**From:**  
**To:** [DCAdmin](#)  
**Subject:** 61-65 New Street, Huddersfield HD1 2BQ - Application number 2021/93305  
**Date:** 21 December 2021 15:35:11

I am writing to make certain comments in relation to the above numbered application which is for a change of use, conversion and extension of the premise referred to above.

ELEVATION 5 - (PARTIAL) RAMSDEN STREET

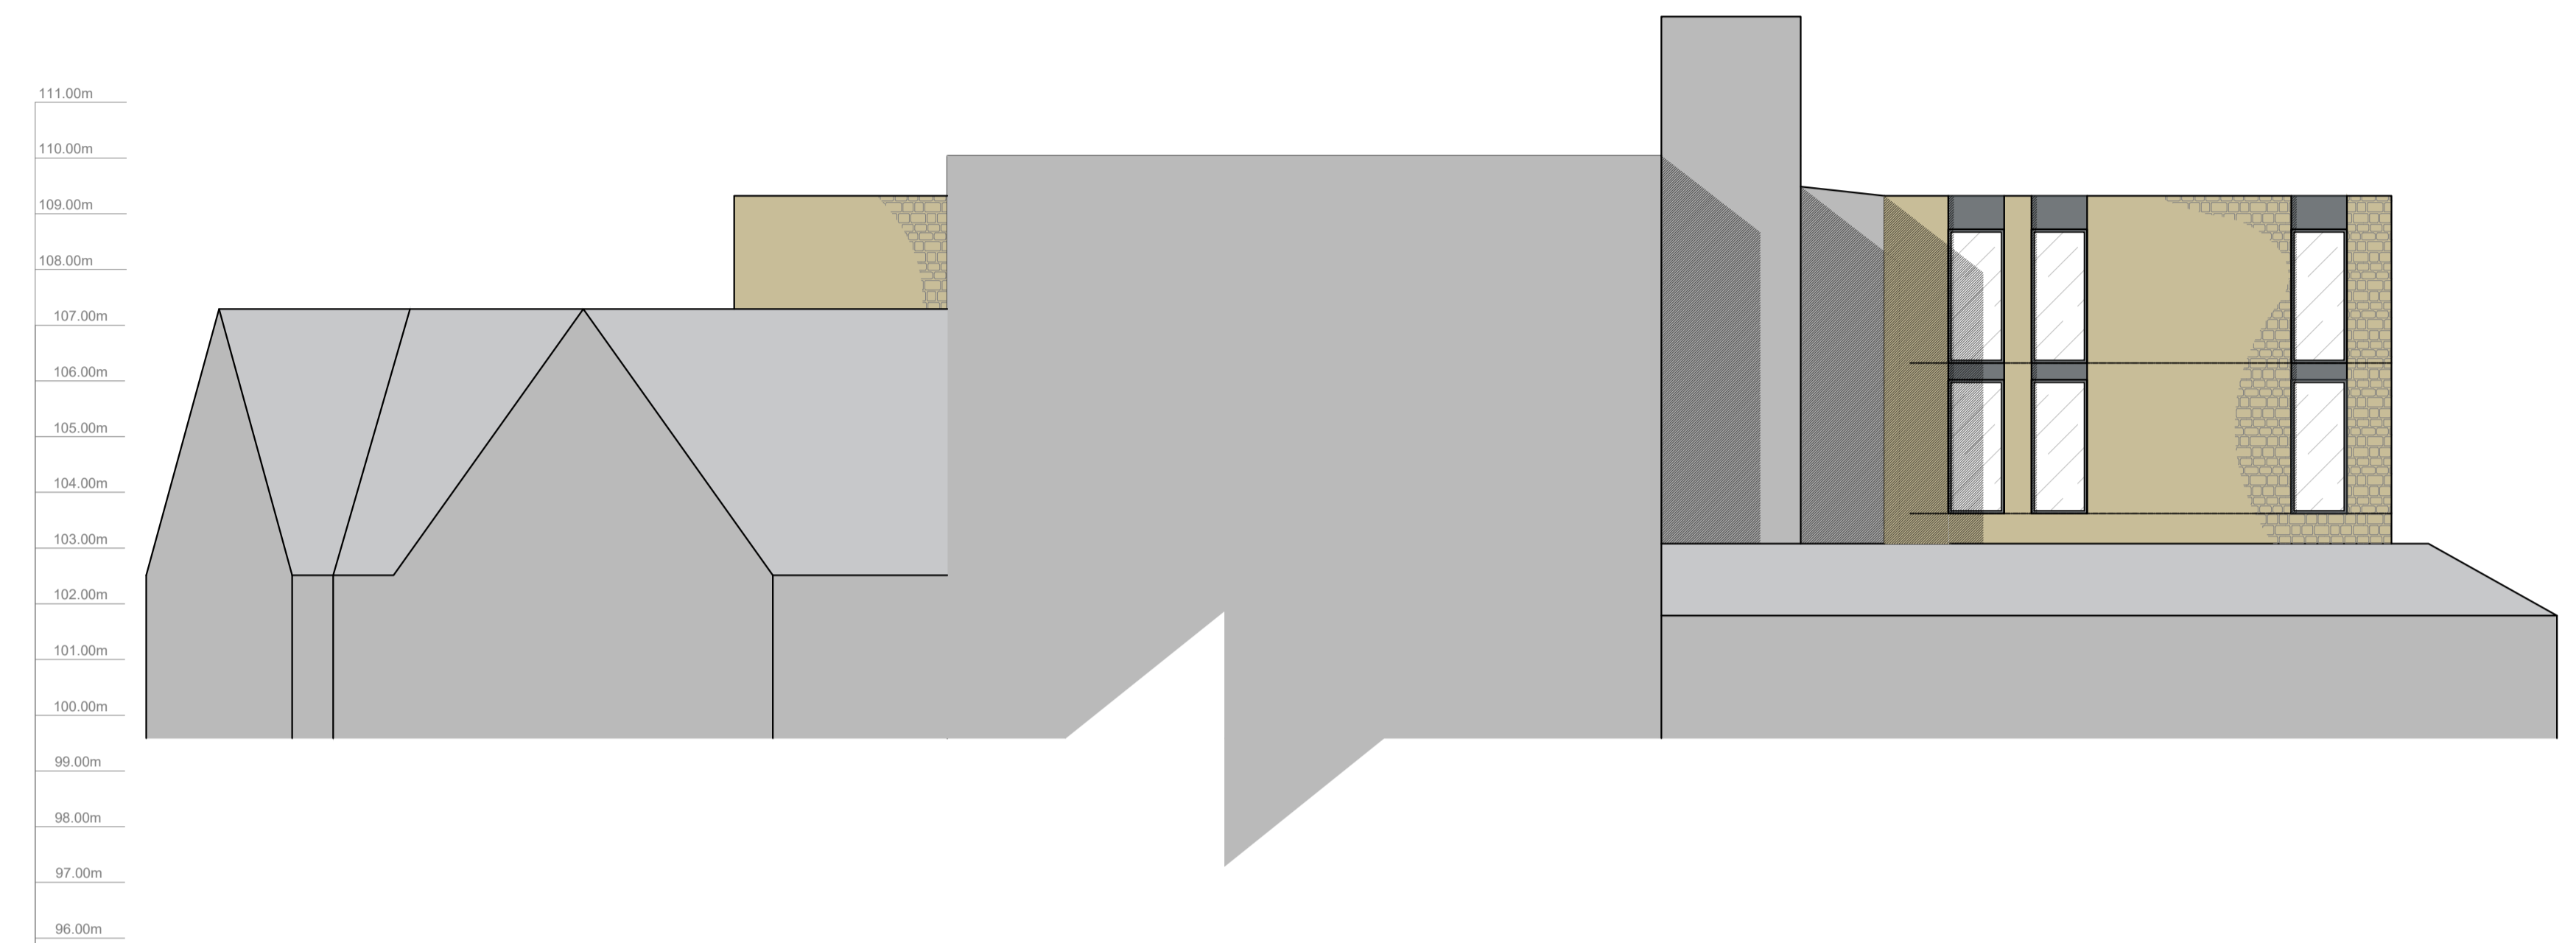
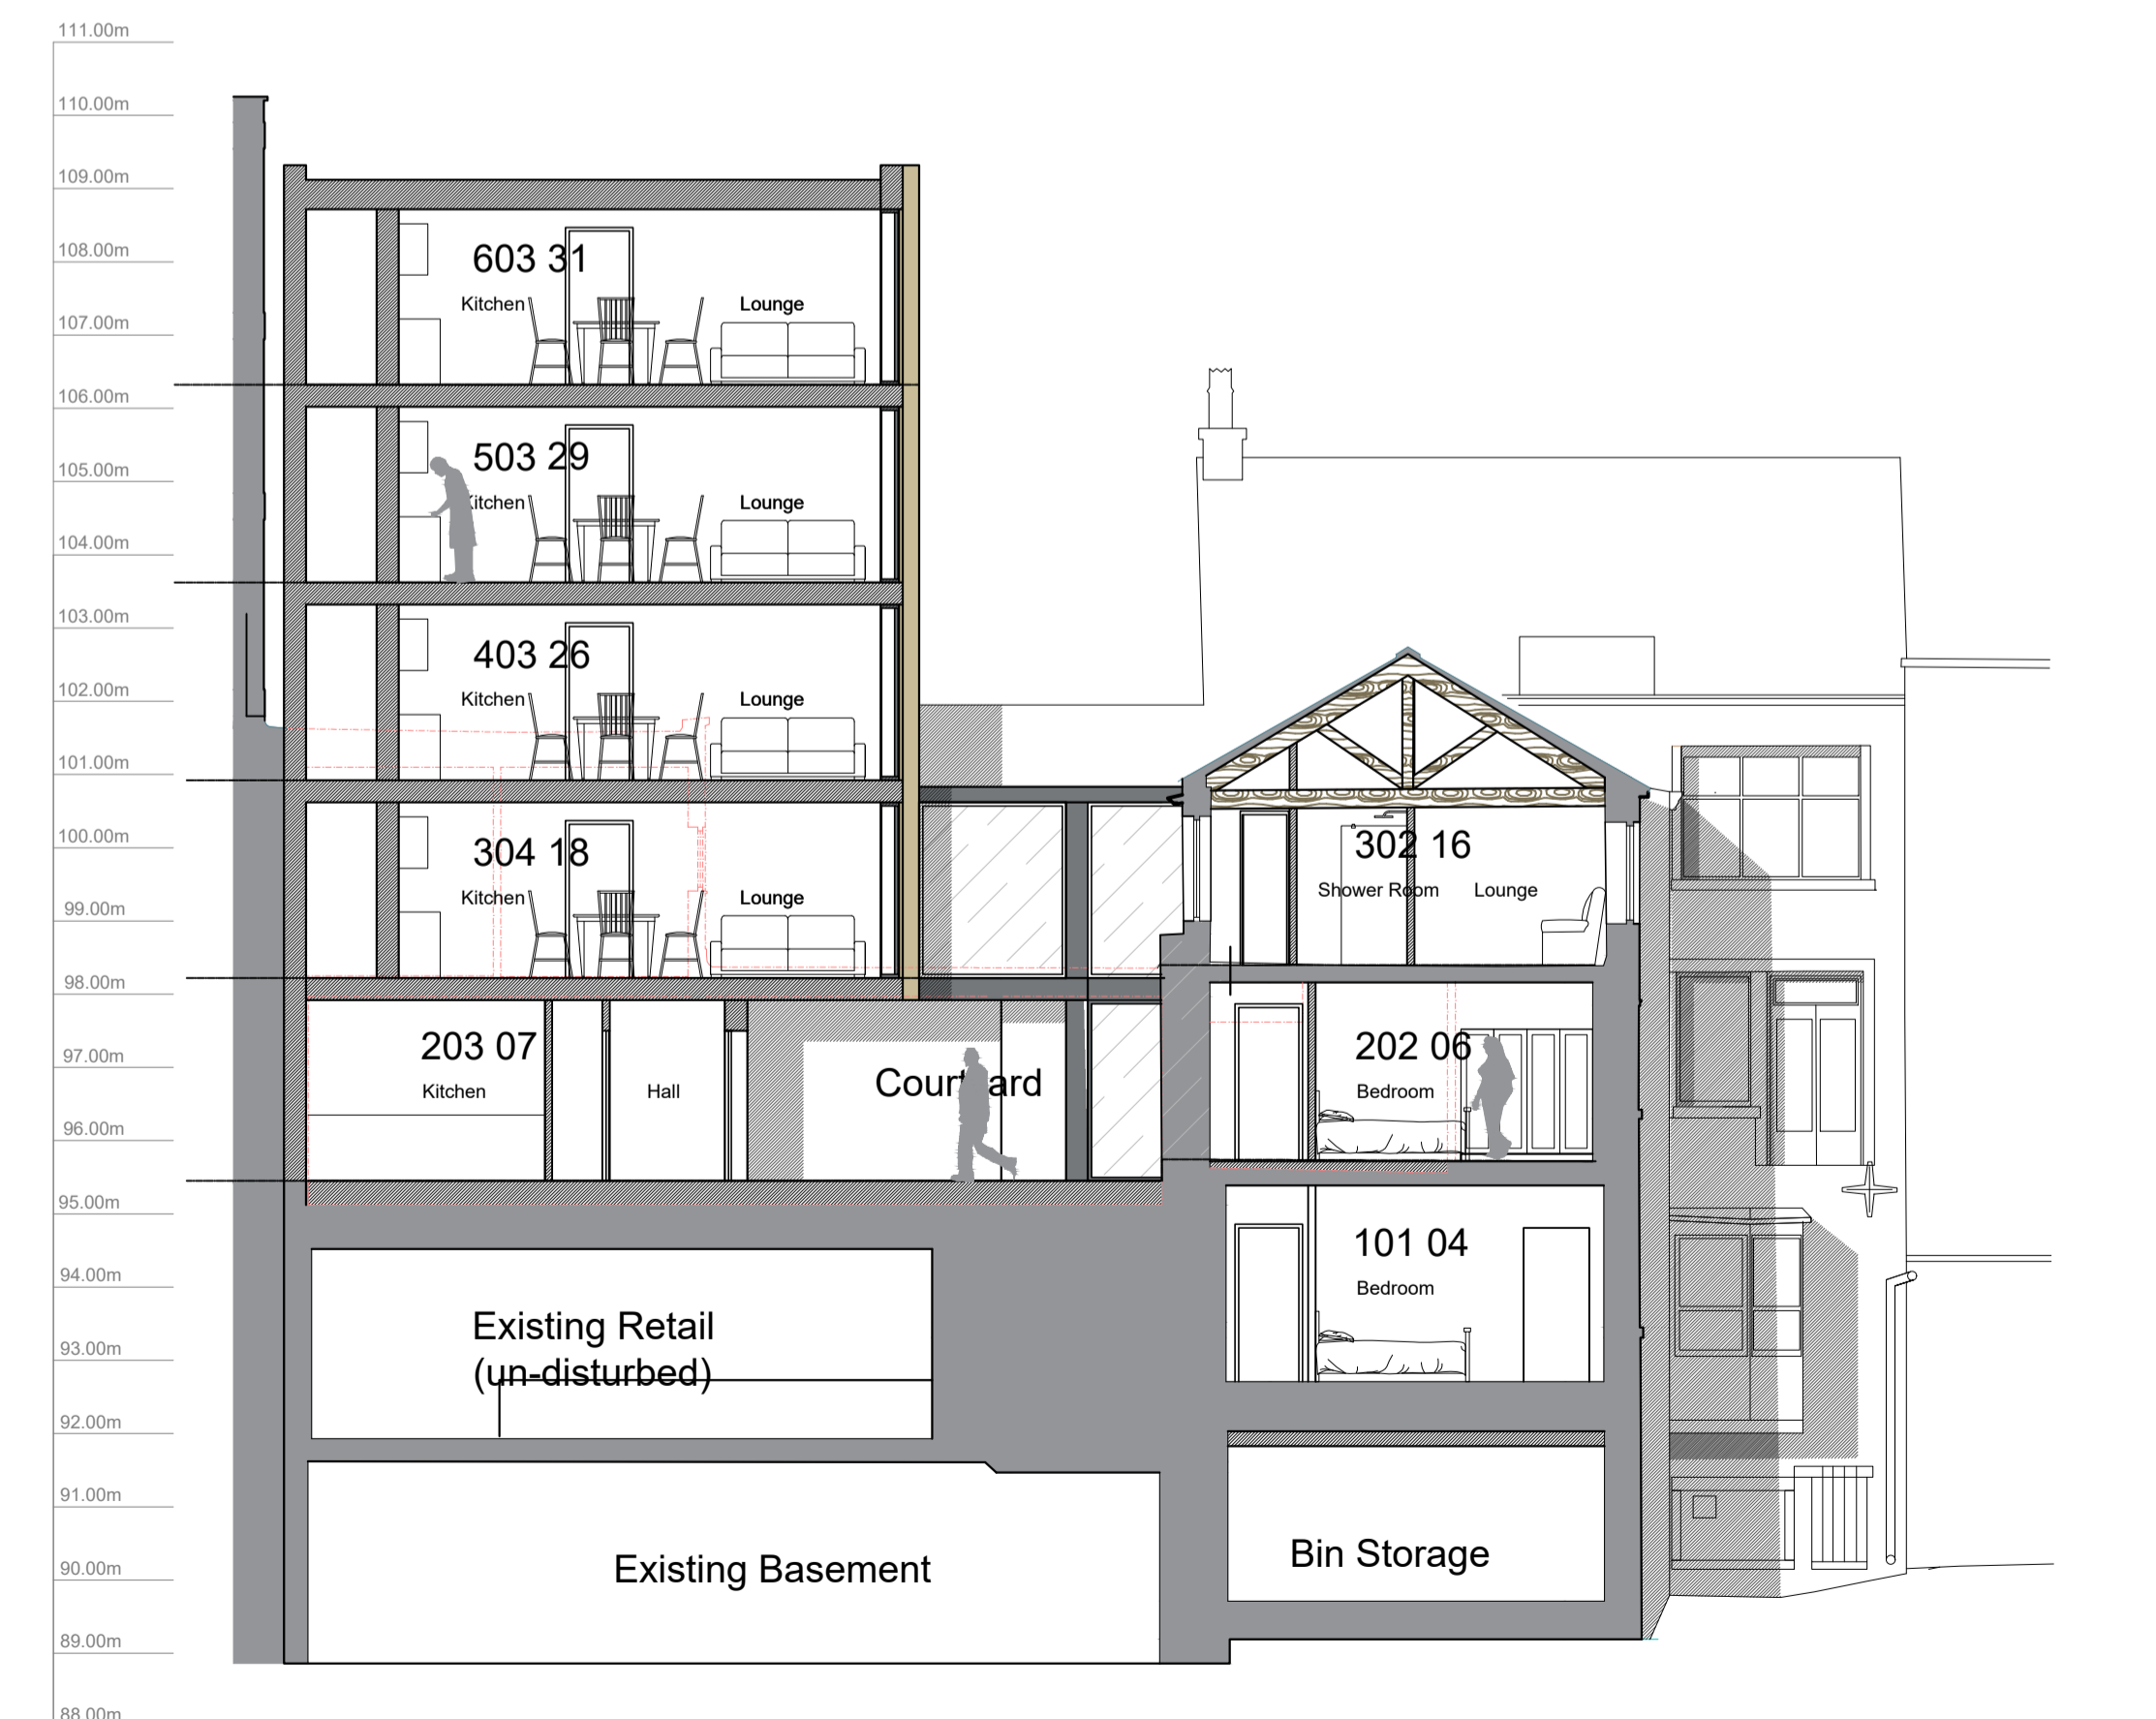
- 3 The proposed development would entirely block all the windows in the rear elevation of our building as the proposed new building would abut the rear elevation and be built to the same height. There is no provision for nor indeed any realistic possibility of getting natural light to those windows. The developer does not have our consent to block the windows.

- 5 We have a fire escape route which runs through this proposed development and this must be preserved or adequately rerouted.
